Demolition of existing buildings (car show room, workshops and Phares Courtledge) and erection of 19 dwellings, a convenience store, a community building, public toilets and associated car parking and landscaping - This application affects the character and appearance of the Angmering Conservation Area.

Bmw House, Chandlers Garage Ltd Water Lane Angmering

Thank you for your internet representation made on 14th May 2019 which has been recorded as '**an objection**' with the comments as follows:

DRAWING TITLE
Plots 7-11,
House Types A,B,D & E,
Elevations

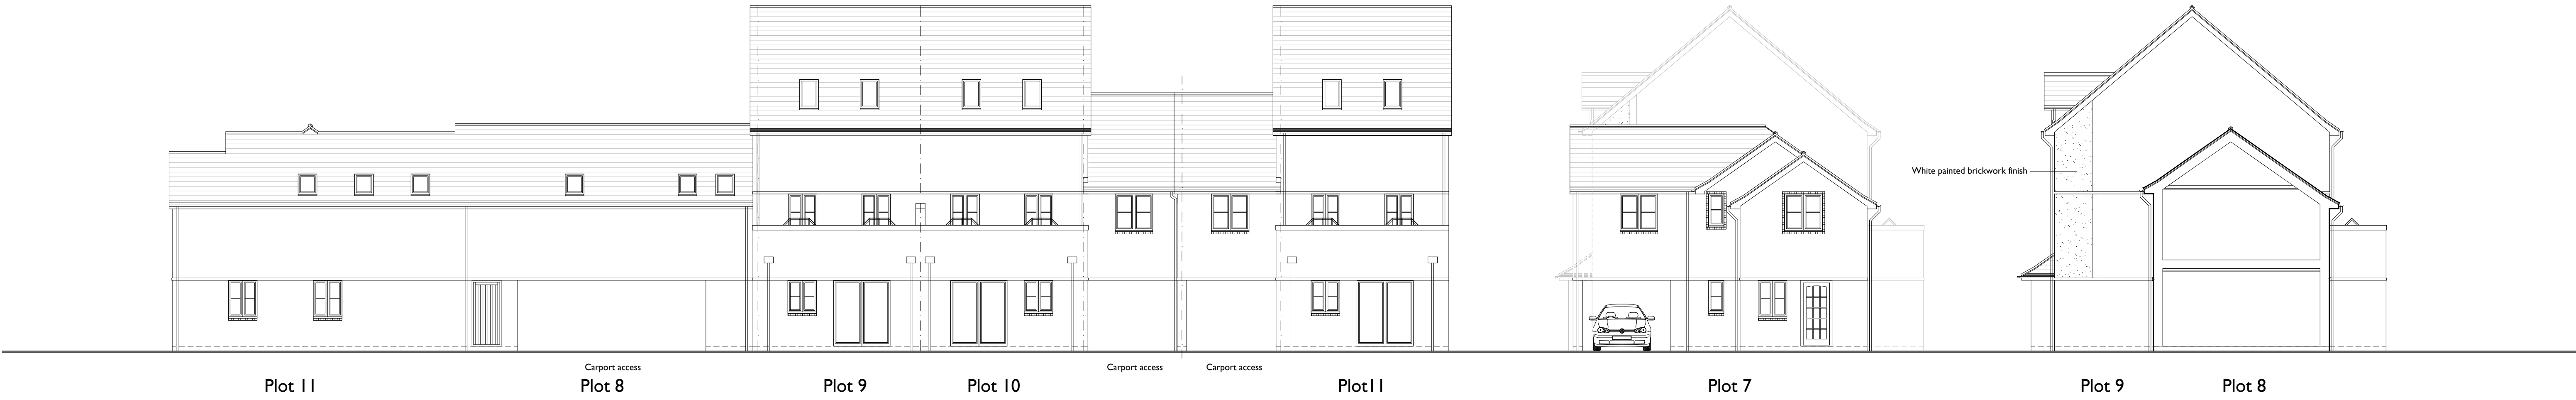
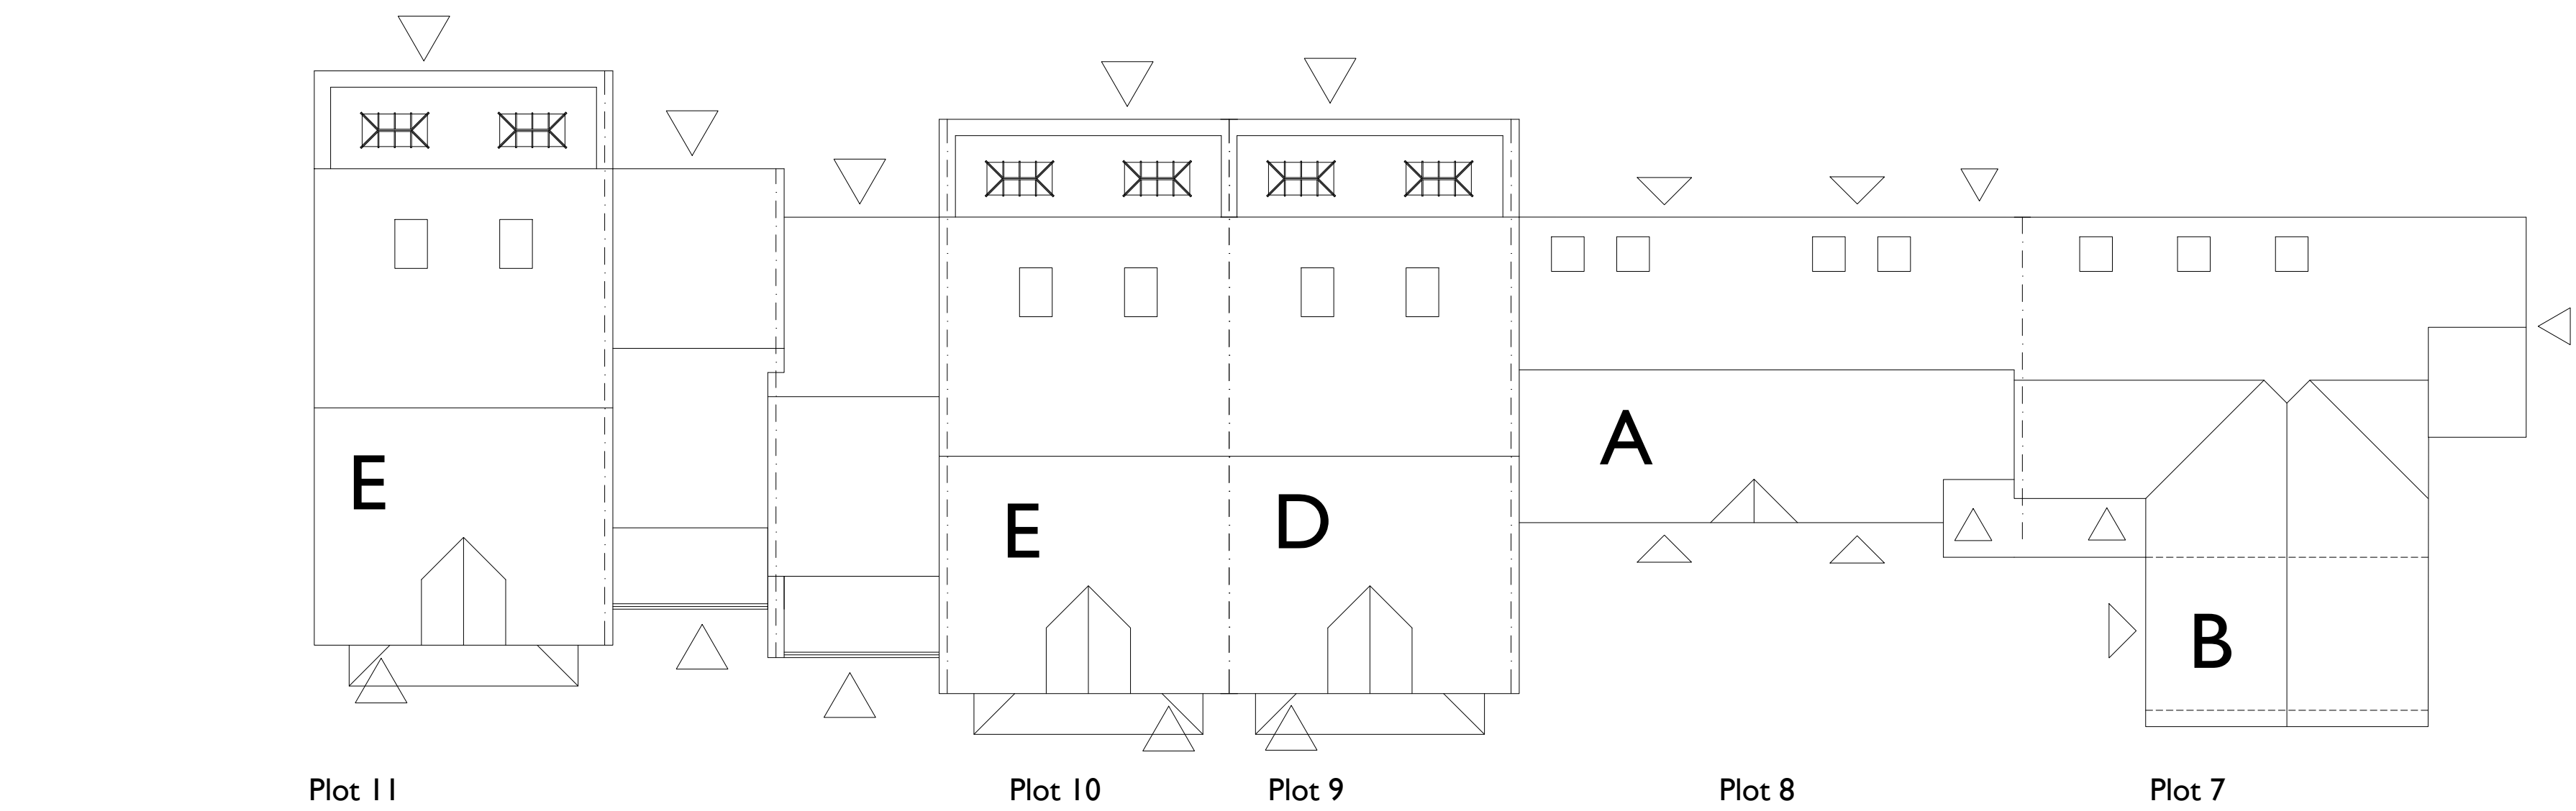
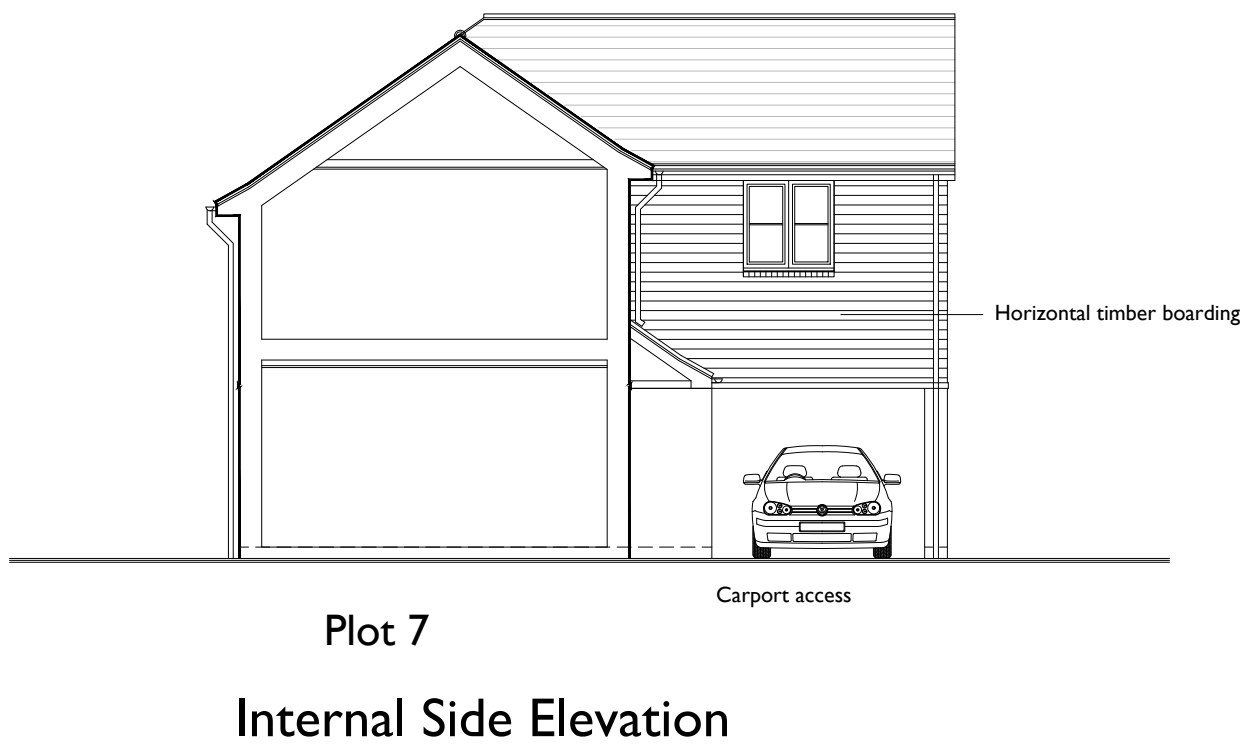
Plots 7-11

These are of poor design and do not reflect the character of the village center, the removal of the roof accommodation is required. I accept the ability to create "rise and fall" within the scheme and additional height in this block is possible this should be done with use of conservation veluxes. I am not of the opinion two and half storey is acceptable in this location.
